RE: Site Plan - Major Amendment, 1700 Unser Blvd NW (SP-2025-00041)

I've completed a first review of your request to remove 1700 Unser Blvd NW (SP-2025-00041) from the Heritage Marketplace Site Development Plan. We have a few questions and suggestions for the process. Following this review, we will be available to answer any questions. Please provide the following:

RIO GRANDE ACADEMY OF FINE ARTS CONCEPTUAL SITE PLAN FOR SKETCH PLAT

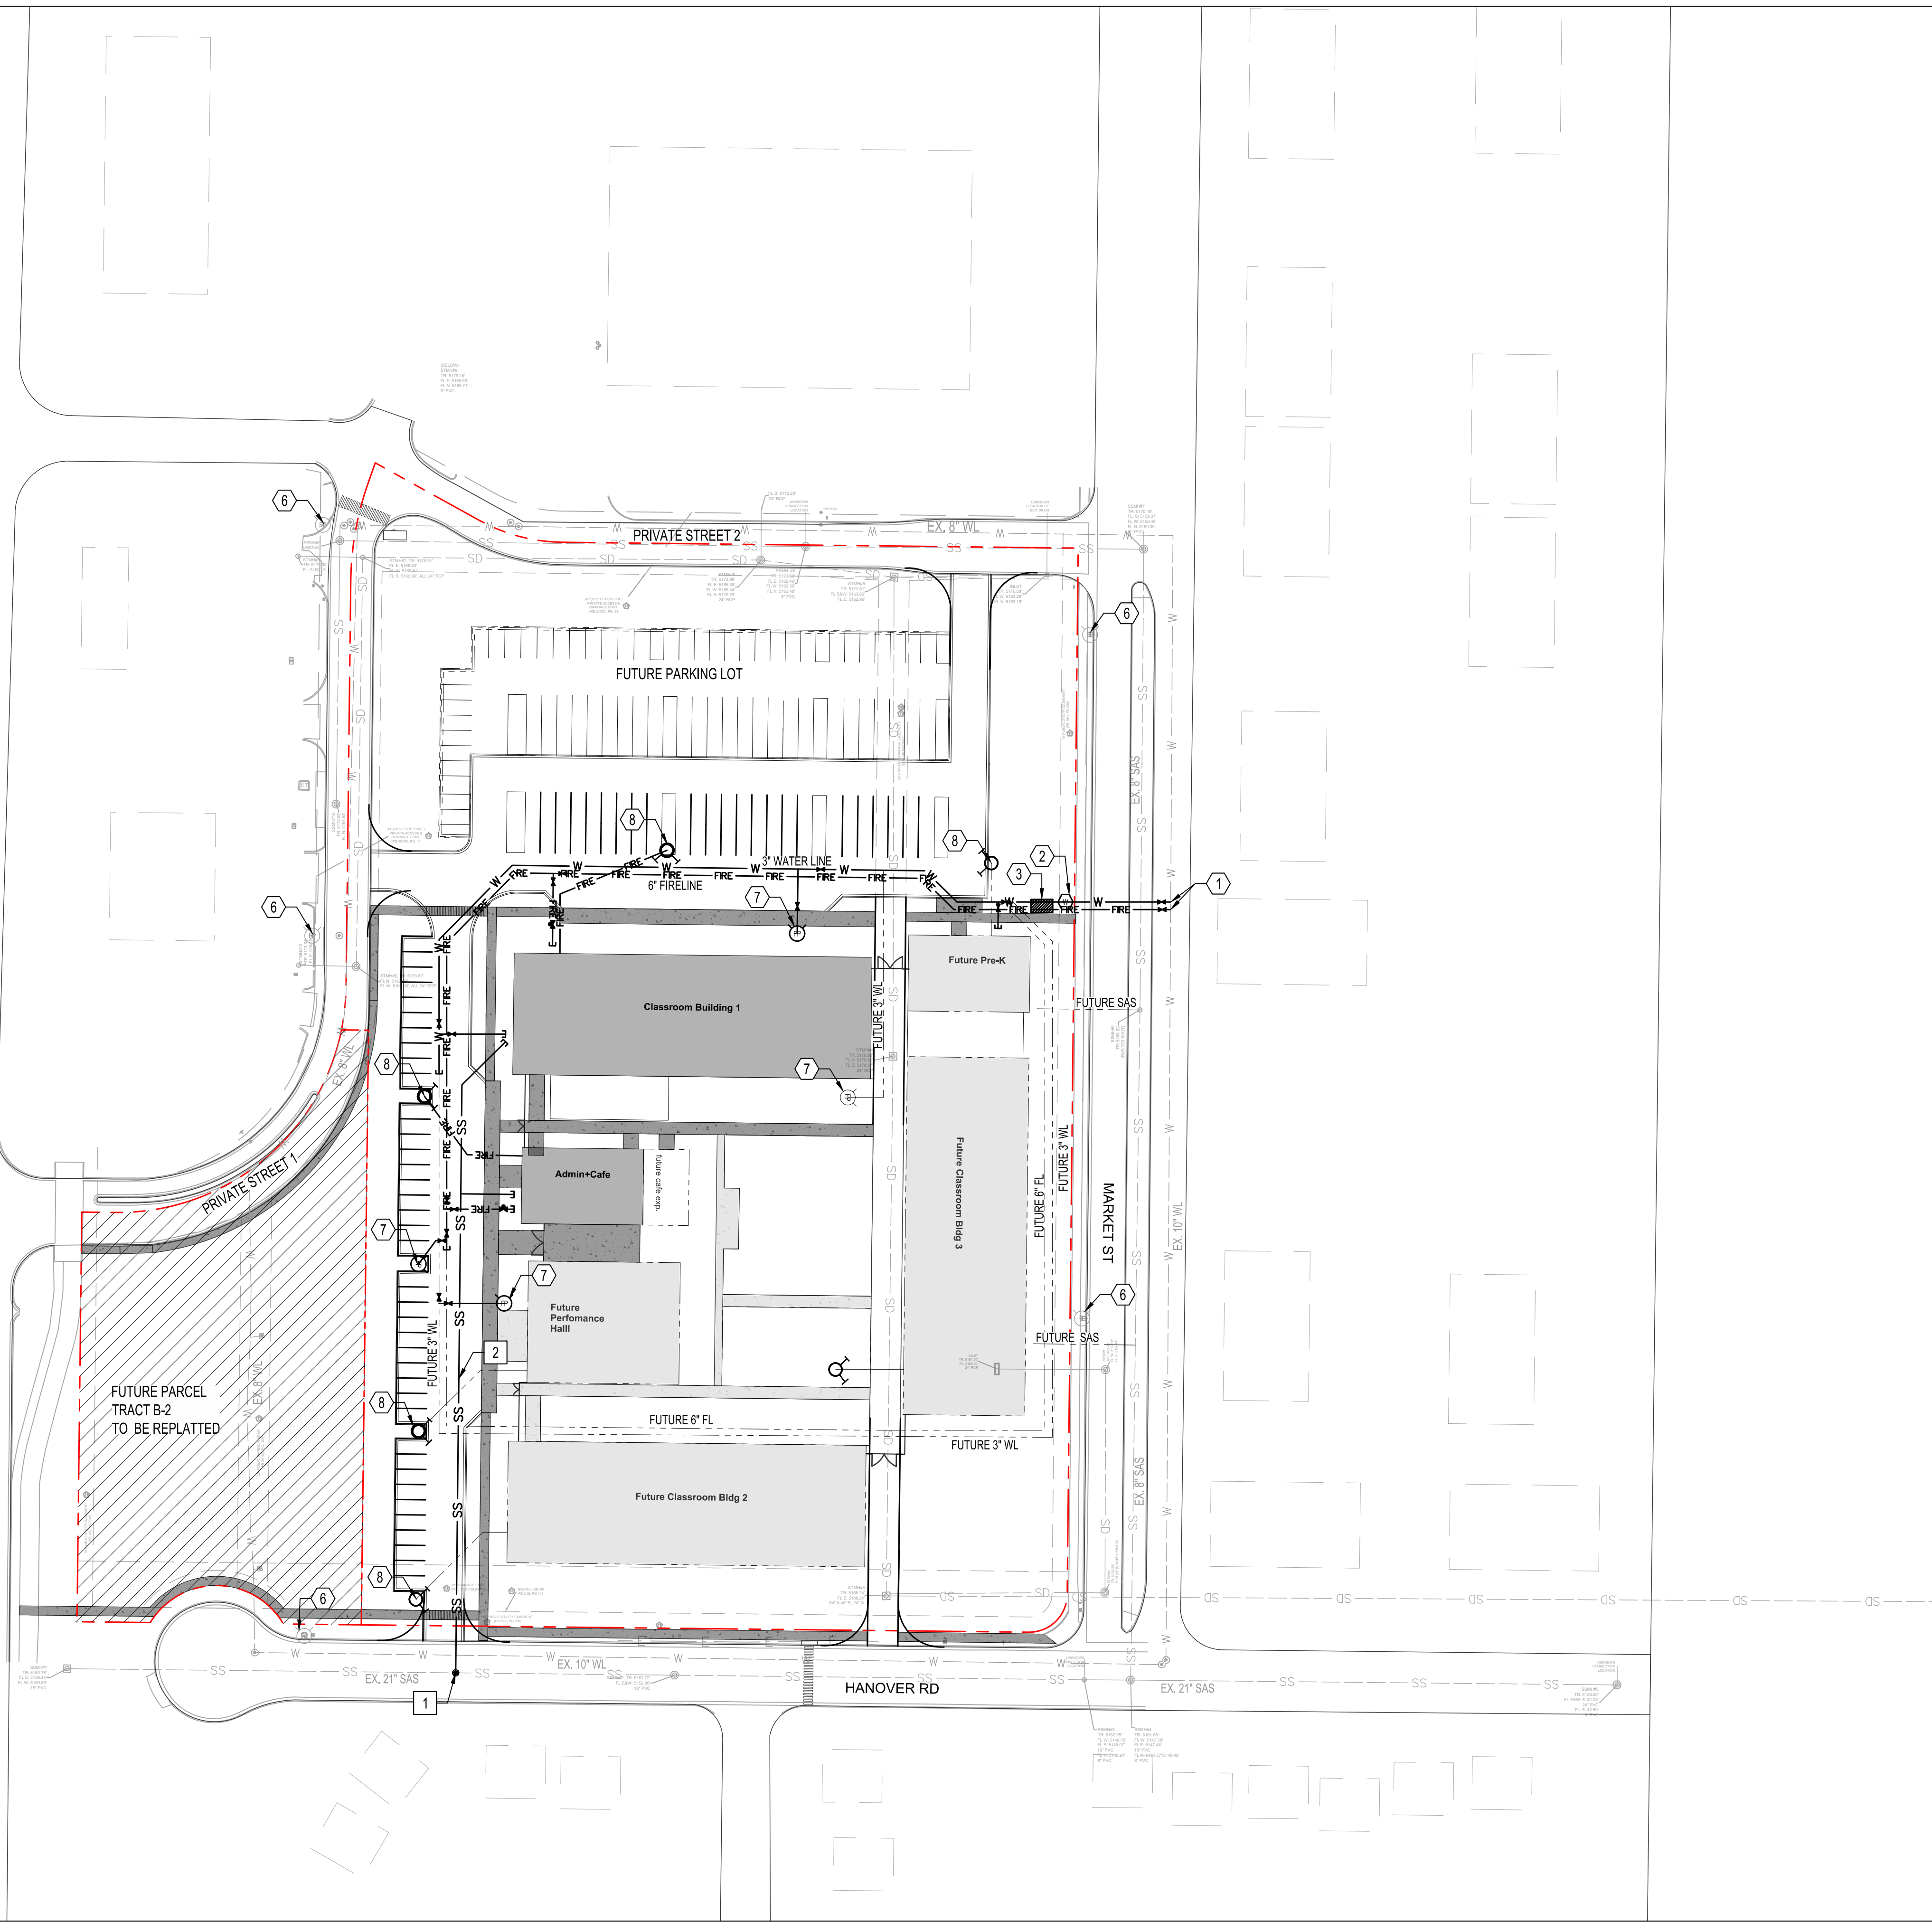
1. The complete Site Plan for Subdivision should be included with the application. The Site Plan for Subdivision provided includes Page 1 of 3 and Page 2 of 3. Is there a Page 3 of 3? If this page exists, it should be added to the submission with any proposed updates added.
2. The provided Conceptual Utility Plan is not needed as it is conceptual and will need to be updated with any future proposed Site Plan.
3. The Site Plan for Subdivision acreage will change with the removal of the subject site. Please update the acreage under “THE SITE:” on Page 1 of 3 of the provided plans.
